**Re: SSD 6799 Swire Cold Storage Facility, Sydney Business Park, Marsden Park**

I refer to your correspondence dated 10 August 2015, requesting that Council provide comments on the proposed State Significant Development lodged under Part 4 of the *EP&A Act 1979* for the Swire Cold Storage Facility.

## ATTACHMENT A

Discipline	GENERAL
Drawing No.	2520460-96-0-502
Rev.	B

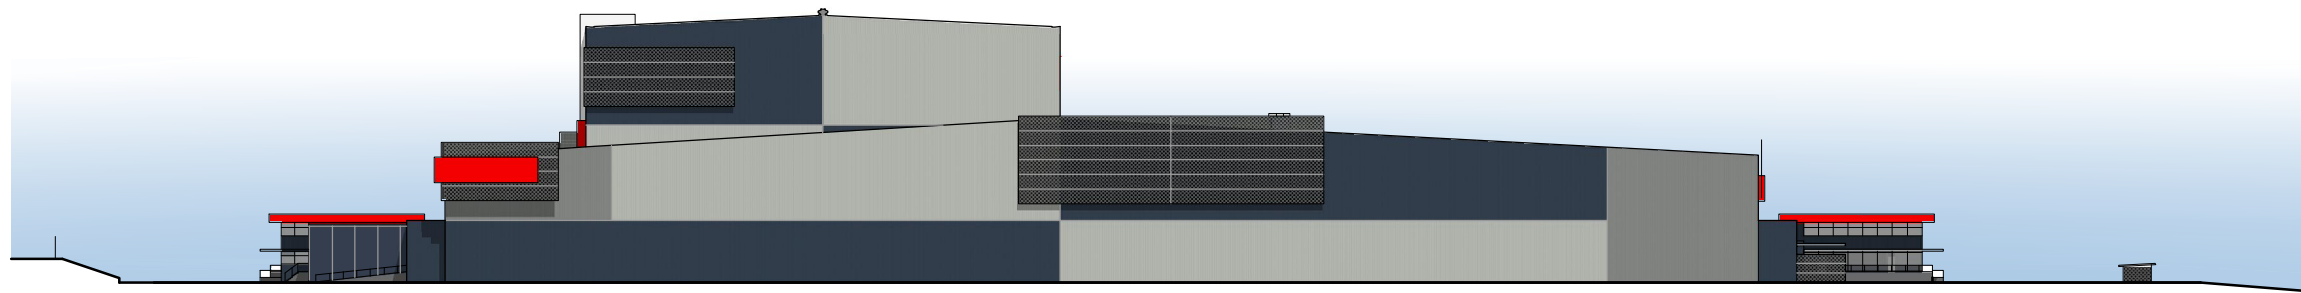
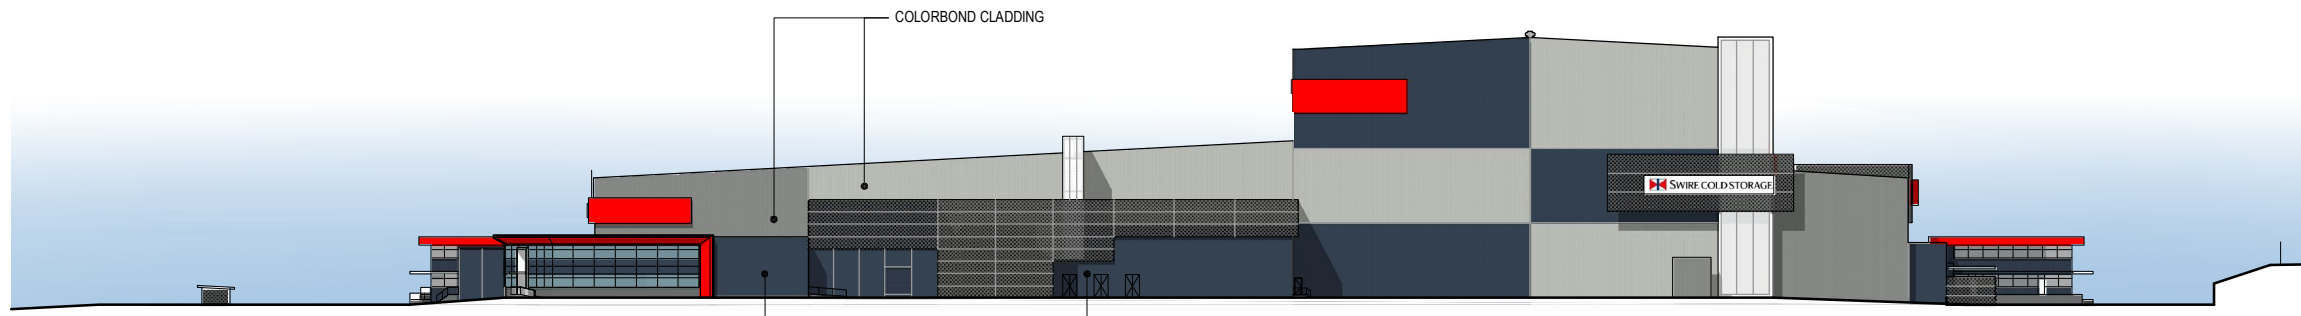
- b. This proposal is located in a prominent part of the estate on the corner of two sub-arterial roads. The high-bay component has dimensions of 57.1m x 126.8m, comprising 70% of the southern façade to Hollingsworth Road and 43% of the western façade to Road No. 2. Therefore, the proposed height exceedance will be readily visible by the public in a part of the precinct that is subject to the lowest height standard.

4. Details of screening to all tanks that are proposed to be visible to a public road / place.
5. Full details of external finishes and colours including photomontages. Council is very concerned at a lack of architectural merit and treatment to the 33m high building. The plans provide no mix of colours and finishes. The colours are considered to be too dark and will impact on the skyline.

6. Particular concern is raised with the elevation to Hollinsworth Road, which is a major collector road, the elevation is unacceptable in its current form as it is just a 'shed' with no mix of finishes, the building should have more masonry elements.

Photomontage - View from Richmond Rd / Hollinsworth Rd Intersection

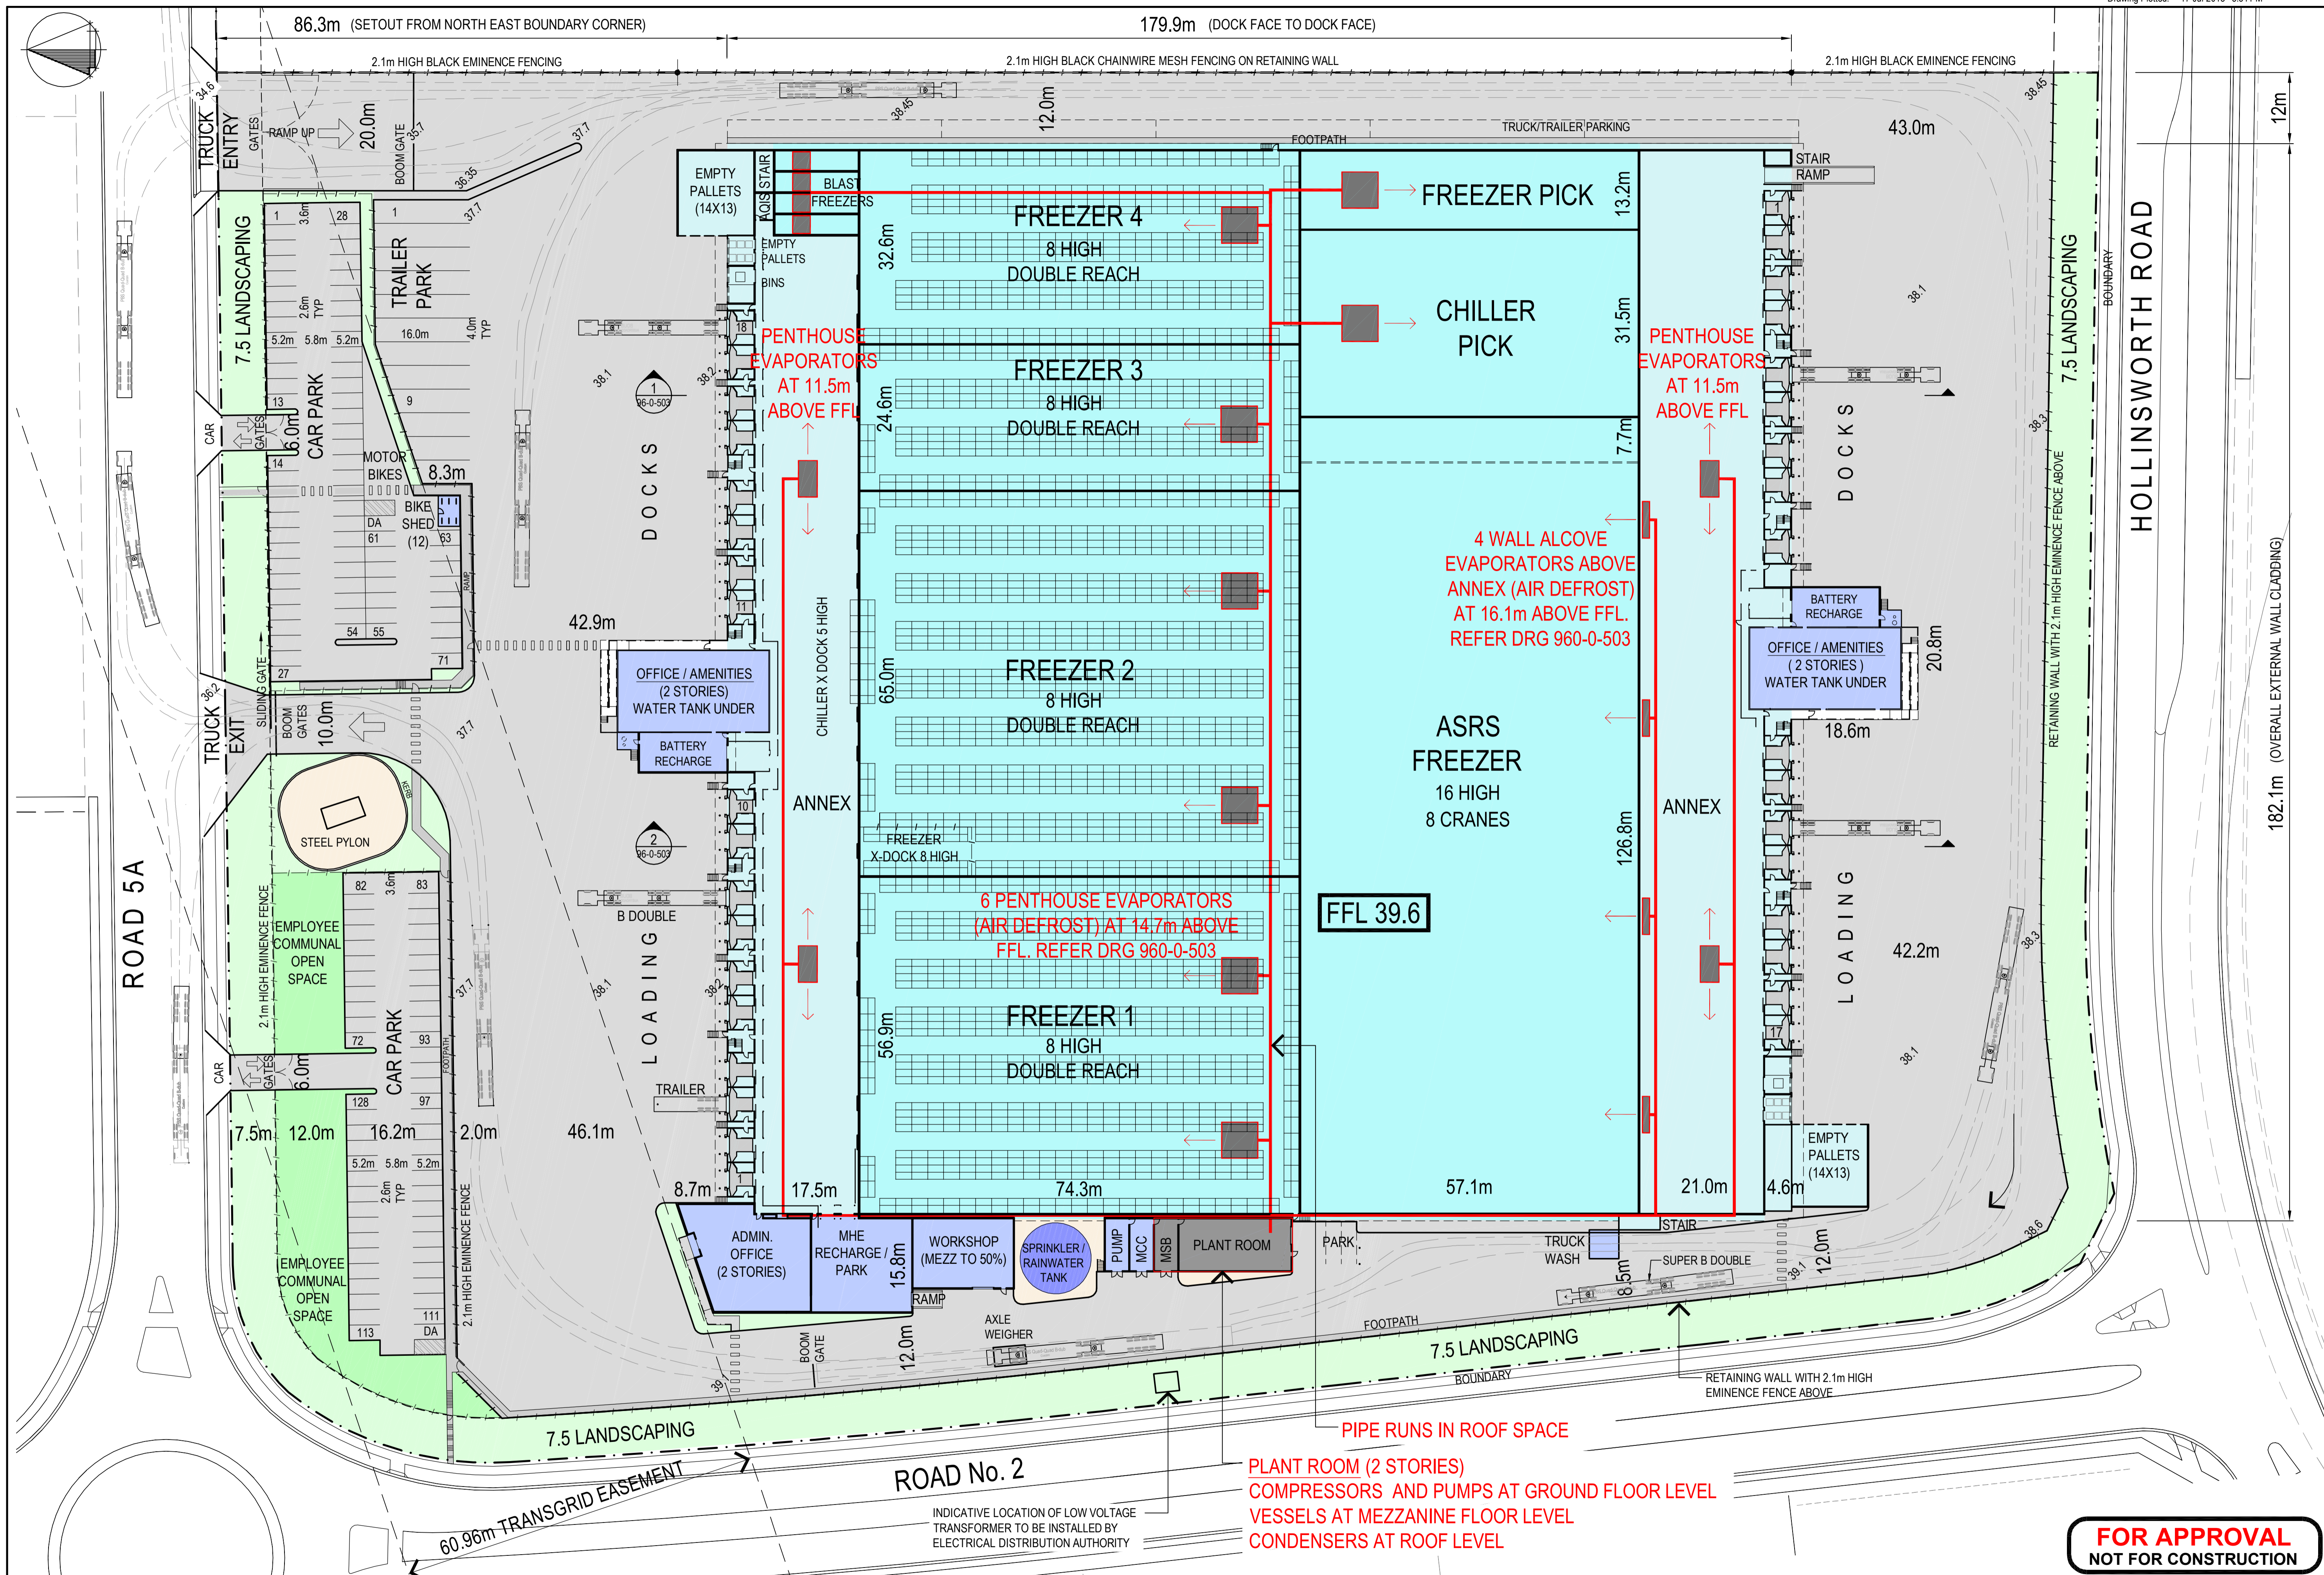
- c. No analysis or supporting information in the form of photomontages and streetscape elevations along Hollingsworth Road and Road No. 2 have been provided to demonstrate the effect of the variation on the desired future character of the locality and bulk and scale in the streetscape.
